# ENG-SF19009-V3-CD-redlines.pdf Markup Summary

**Subject:** EPC ENG Review  
**Page Index:** 1  
**Date:** 5/15/2020 10:27:39 AM  
**Author:** dsdrice  
**Color:** ■  
**Layer:**  
**Space:**  
**Page Label:** [1] Layout1

ANTELOPE RAVINE DRIVE
 (50' R.O.W. - URBAN LOCAL)
 DESIGN SPEED 25 MPH

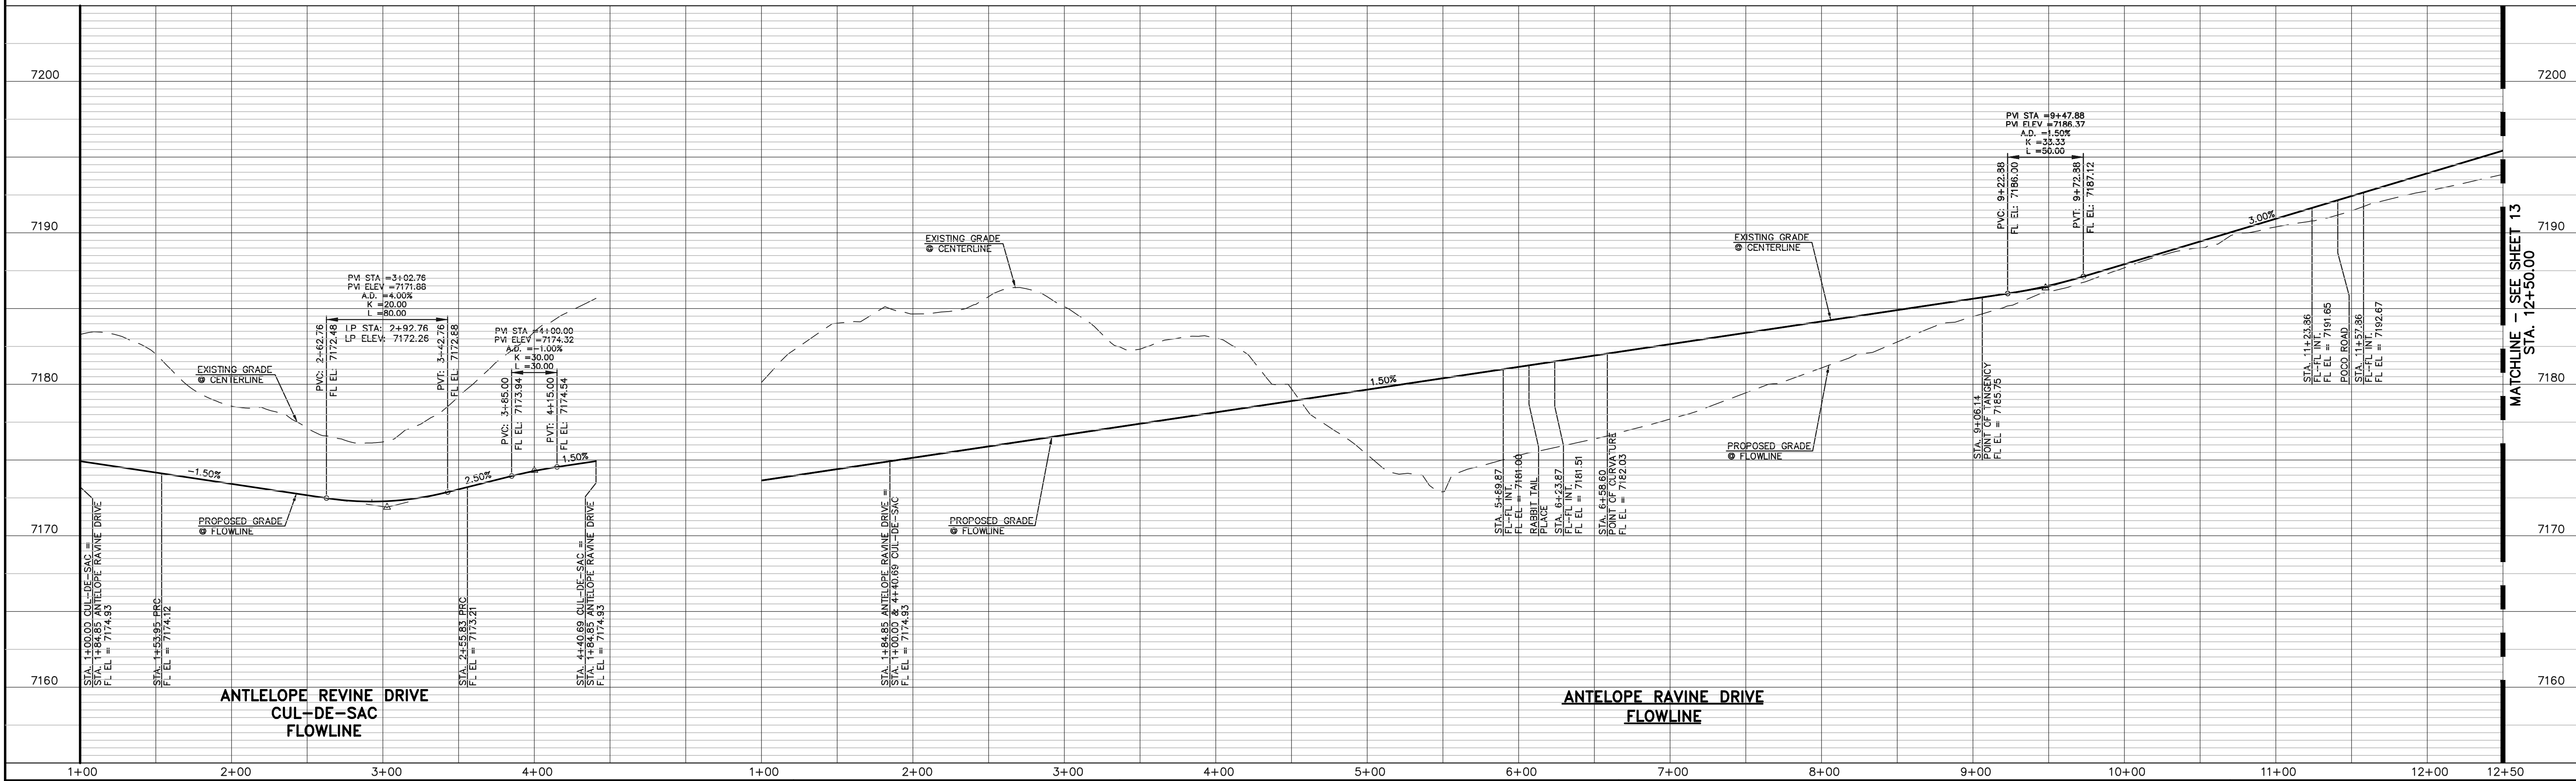
verify pedestrian crossing meets ADA <2% cross-slope.
